Subject: Concord Hospital Concept Proposal & Stage 1 Modification 7 (SSD-9036-Mod-7) – Changes to parking, ESD and Landscaping

Reference is made to the exhibition of the modification application for the redevelopment of Concord Repatriation General Hospital (SSD 9036), located at 1H Hospital Road, Concord West.

Council would appreciate the review and consideration of the following comments provided by council's Traffic Engineer in the assessment of the subject application.

TITLE
**MULTI STOREY CAR PARK
 PROPOSED SITE PLAN**

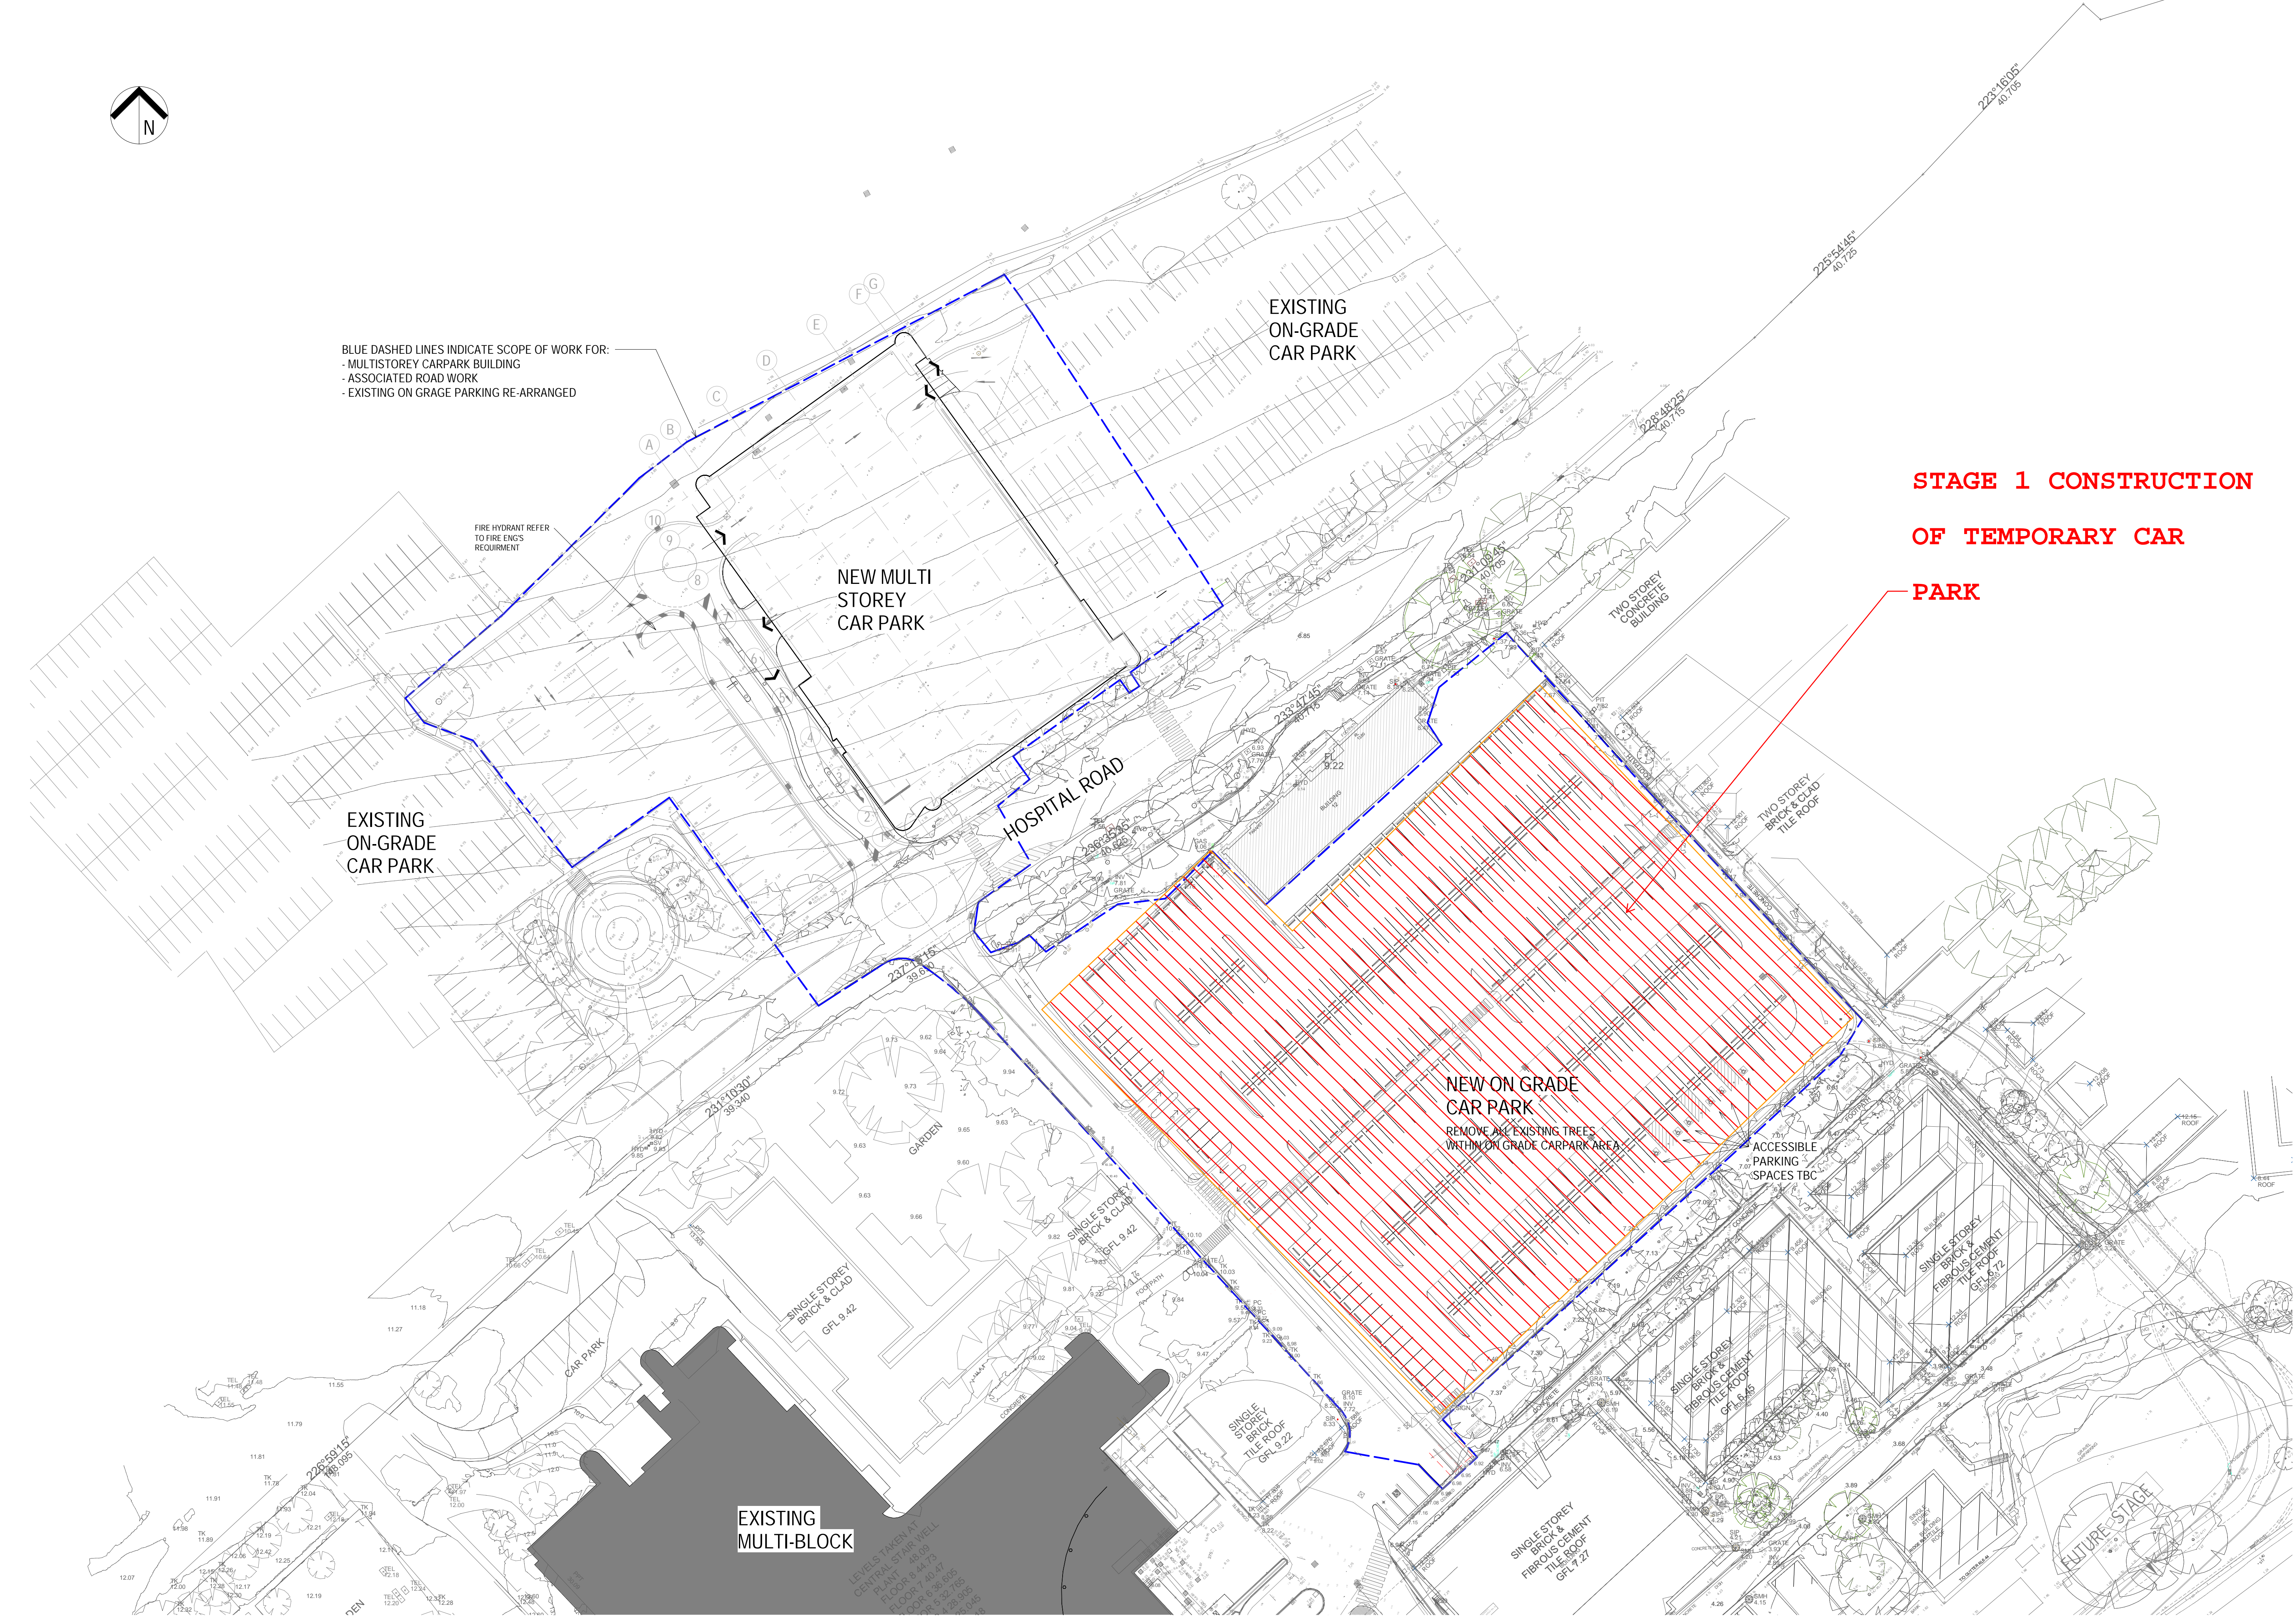
- The documentation submitted in support of the original approved development do not appear to have detailed the timing of constructing the multi-storey carpark in relation to the expansion of the hospital. As such, when Council provided feedback on that application it was not apparent that the construction of the carpark would lag behind the expansion of the hospital. Subsequent staging plans only required approval of the Planning Secretary and did not require consultation with Council.

- It is now apparent that the shortfall in parking will be significantly larger than previously appreciated due to hospital expansion works completing prior to construction the multi-storey carpark. The original Transport and Accessibility Report indicated that there would be 1,949 parking spaces available during construction of the multi-storey carpark. It is now proposed to reduce that to 1,821. This is significantly less than the 1,957 parking spaces available prior to the commencement of the hospital upgrade, notwithstanding the estimated parking demand increasing from 2008 to 2381. The net result of this modification application would hence be an increase in the shortfall of parking from 432 to 560 spaces during construction.

- No mitigation measures for the shortfall in parking are proposed in the Modification application, notwithstanding the proposed increase in parking shortfall. Mitigation measures should be proposed to addressing the shortfall in parking arising from the modification application, as well as the shortfall which has arisen due to how approved works have been staged.
